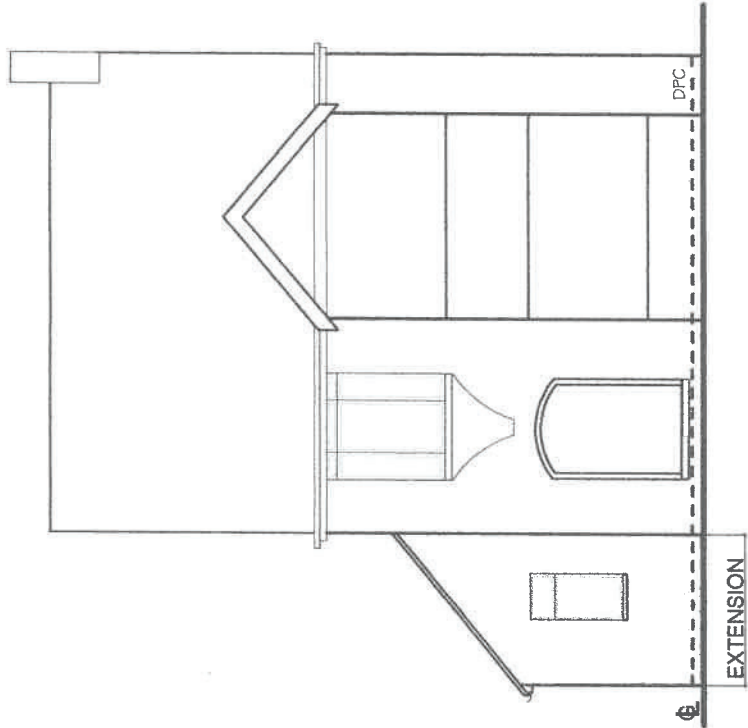
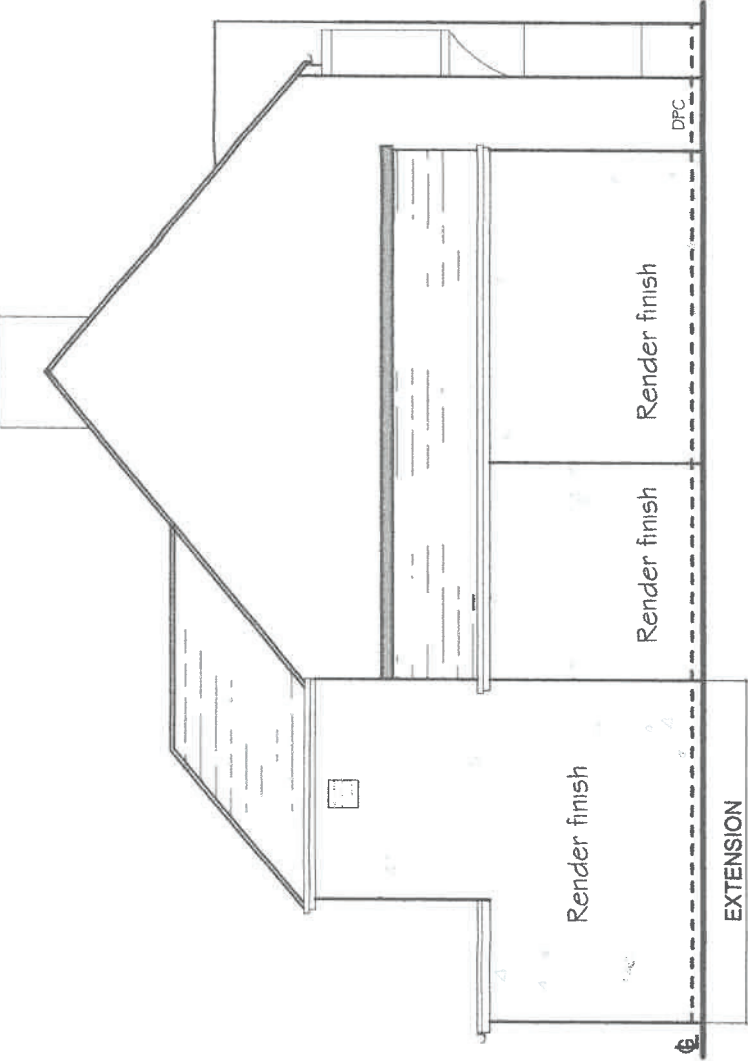
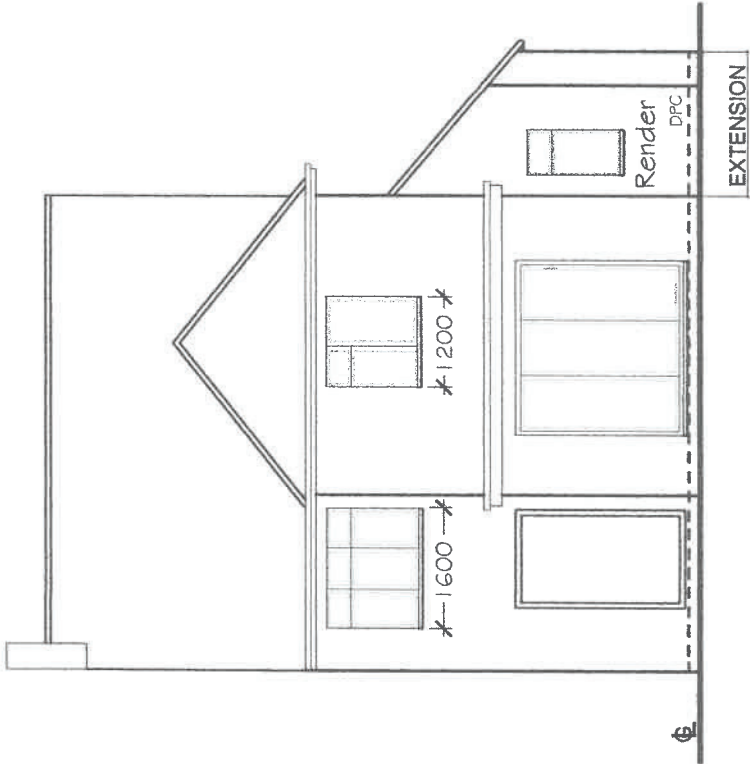
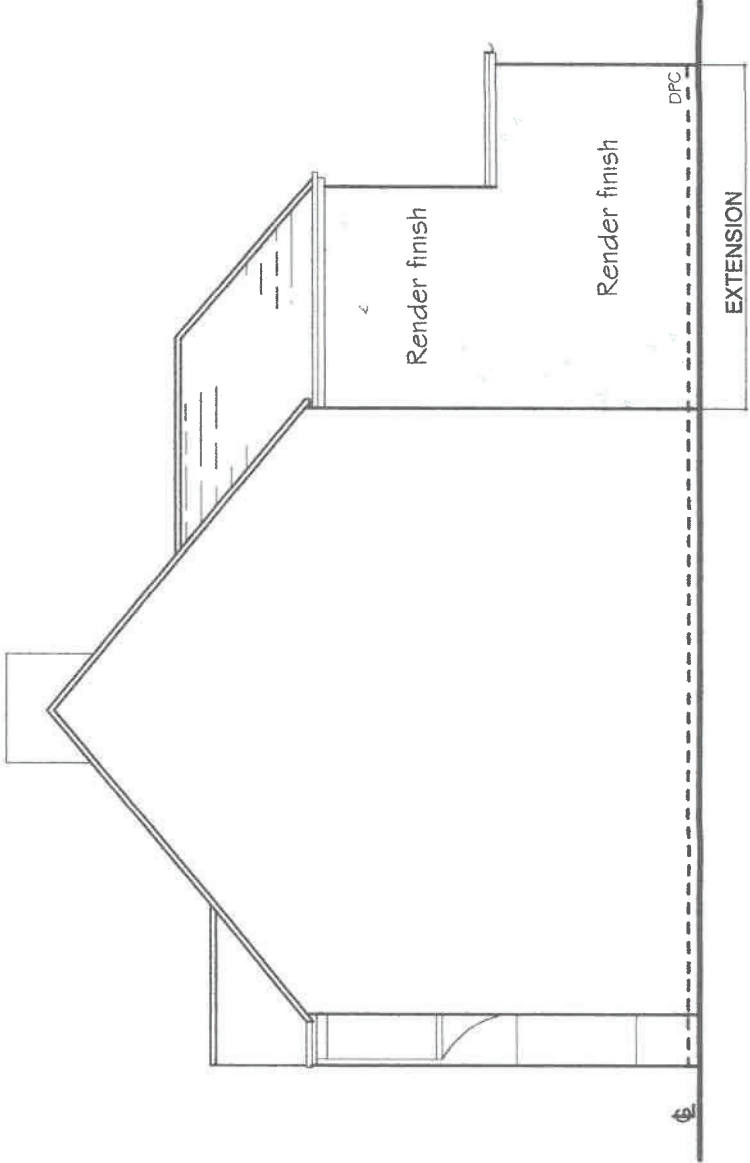
With regards to the discrepancy between the proposed elevations and the proposed floor plans submitted, these plans must match so it is completely clear what you are applying for and if successful what the approval relates to. There cannot be a discrepancy in the plans, they must be amended to show the correct measurements on both.

DRAWING
BLOCK PLAN

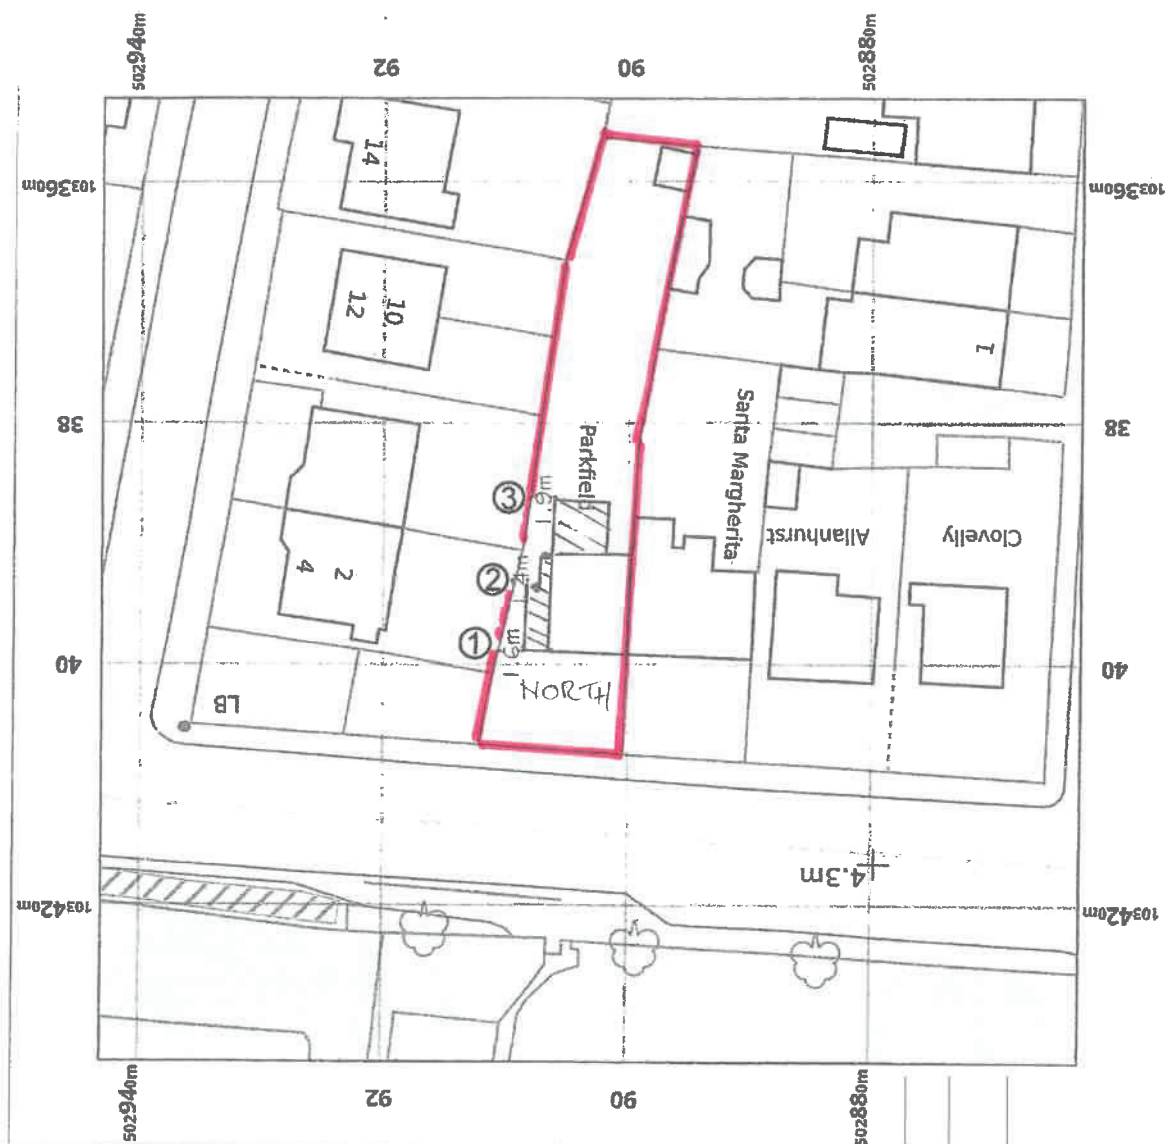
It is a local validation requirement that the written dimensions of the distances of the proposal from the boundaries are shown on the block plan so that it is clear how far the proposed extension is from the side and rear boundaries. The purpose of requiring this is so that anyone with an interest in the development can be clear how far the proposal is
